From: Sarah Burrow <Sarah.Burrow@arun.gov.uk>
Sent: 28 October 2021 12:40
To: Planning.Responses <Planning.Responses@arun.gov.uk>
Cc: Maria Tomalova <Maria.Tomalova@arun.gov.uk>
Subject: RE: Planning Consultation on: BR/201/21/PL

Engineers Comments Regarding Surface Water Drainage

Application No: BR/201/21/PL

Site Address: Ravenna Richmond Avenue West Bognor Regis PO21 2YG

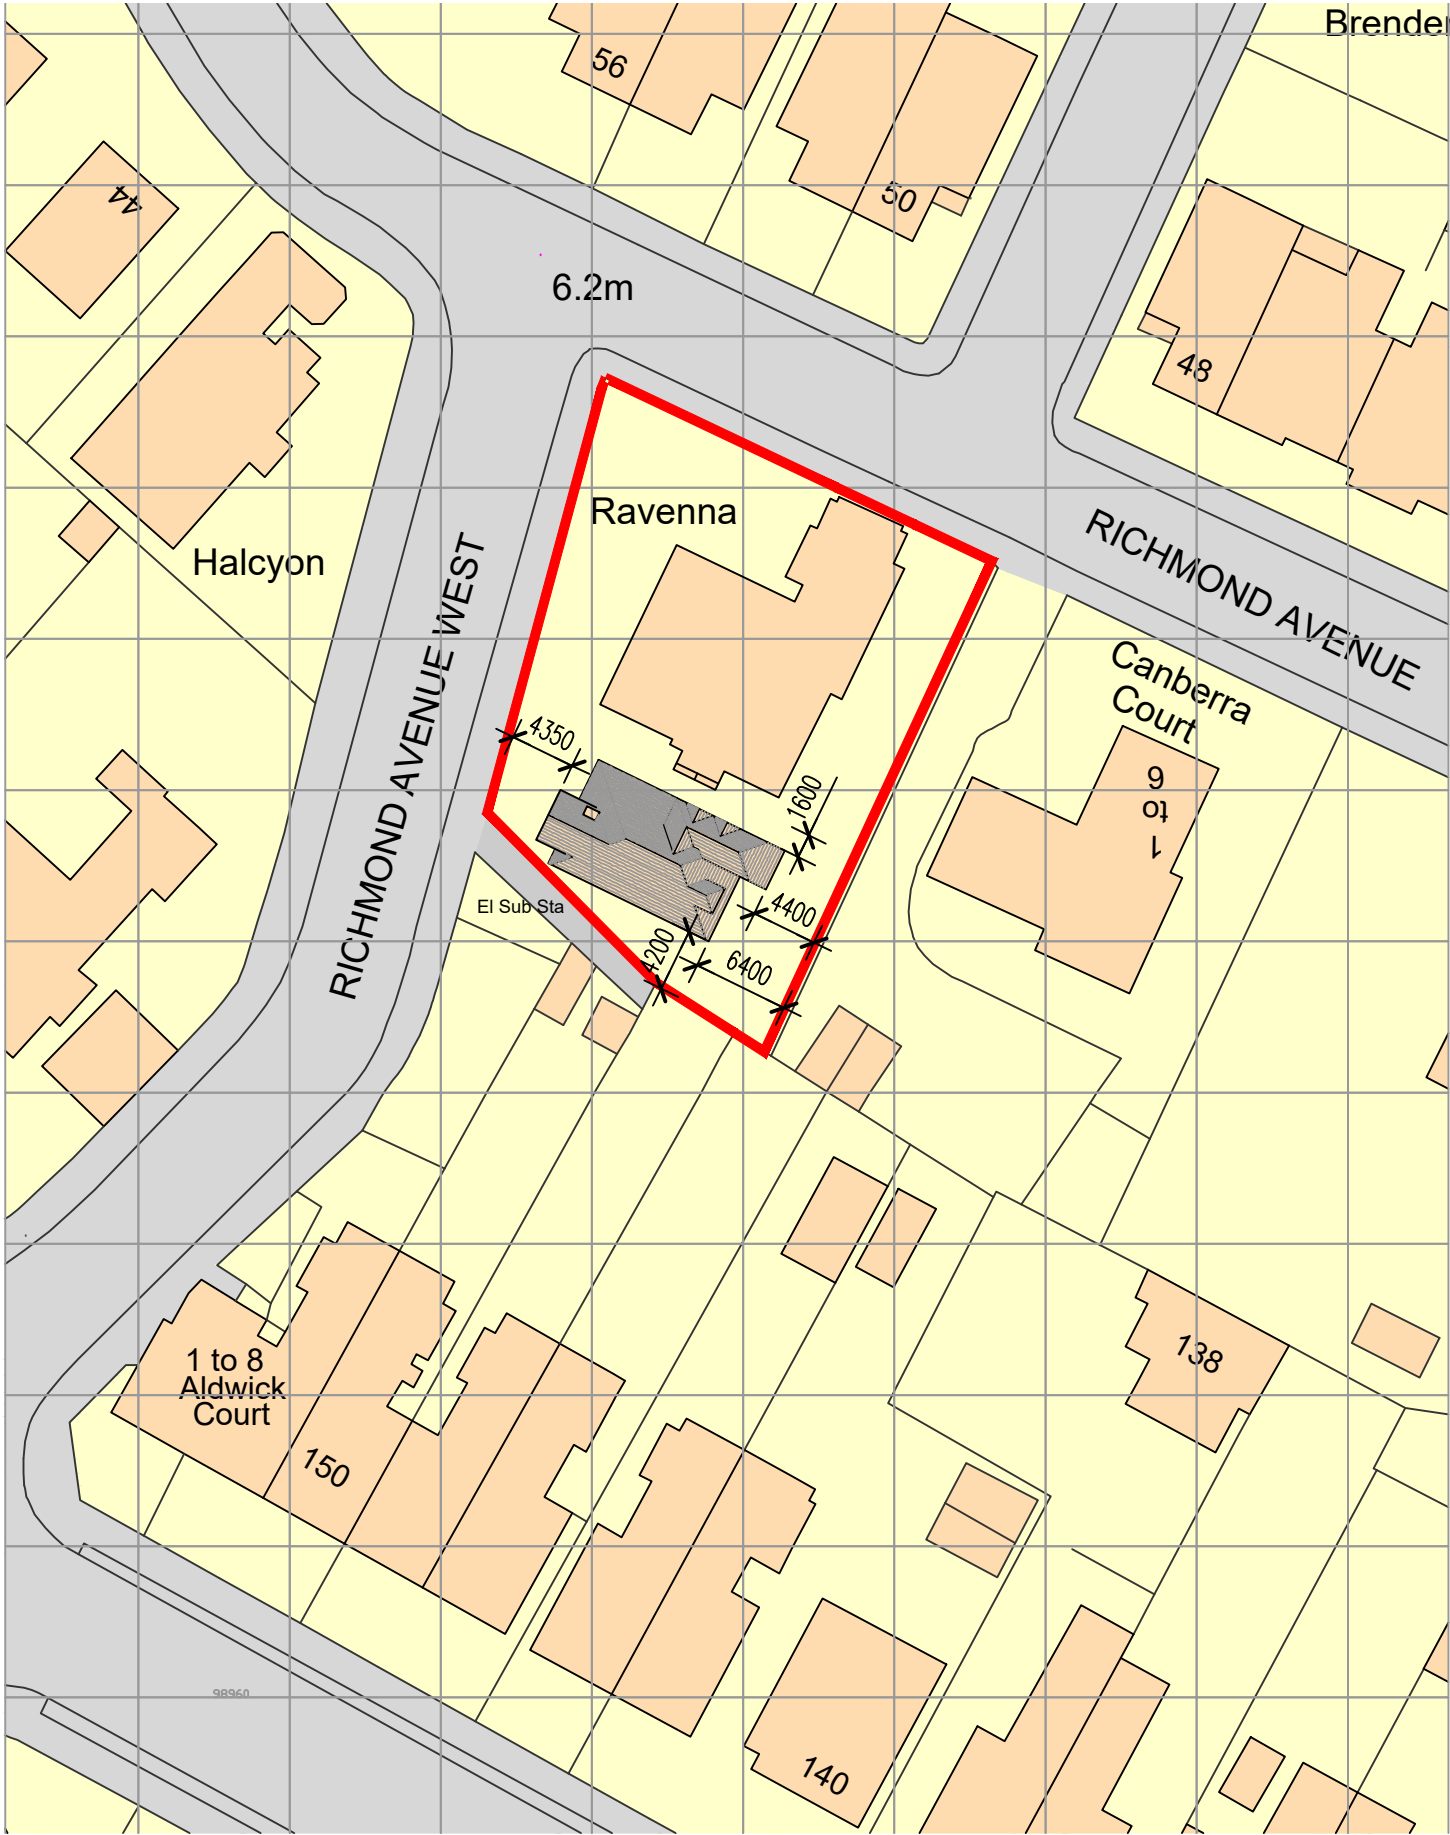
Surface water drainage must be considered at the earliest opportunity. Without winter groundwater monitoring and winter infiltration testing there is no way of determining the area take up required for an infiltrating surface water drainage solution and the hierarchy for sustainable drainage must be followed. If infiltration is viable on the site then lack of space is not an adequate excuse for not utilising soakaways/infiltration structures. Soakaways must be located a minimum of 5m from any buildings, and 2.5m from the site boundaries. Given these constraints, I do not see how surface water from the site can be sustainably drained within the remaining space on the site. There is also the risk that the proposed building may be located on the site of any drainage features for the existing building.

To overcome my objection the applicant should complete winter groundwater monitoring and winter infiltration testing and complete calculations to assess the size of structures required. A rough plan should be formed showing where these structures can be provided within the proposed layout. Detailed design of the system can be left until discharge of conditions where the applicant should provide the level of information stated within our checklist <https://www.arun.gov.uk/drainagechecklist>.

“Development shall not commence, other than works of site survey and investigation, until full details of the proposed surface water drainage scheme have been submitted to and approved in writing by the Local Planning Authority. The design should follow the hierarchy of preference for different types of surface water drainage disposal systems as set out in Approved Document H of the Building Regulations, and the recommendations of the SuDS Manual produced by CIRIA. Winter groundwater monitoring to establish highest annual ground water levels and winter Percolation testing to BRE 365, or similar approved, will be required to support the design of any Infiltration drainage. No building / No part of the extended building shall be occupied until the complete surface water drainage system serving the property has been implemented in accordance with the agreed details and the details so agreed shall be maintained in good working order in perpetuity.”
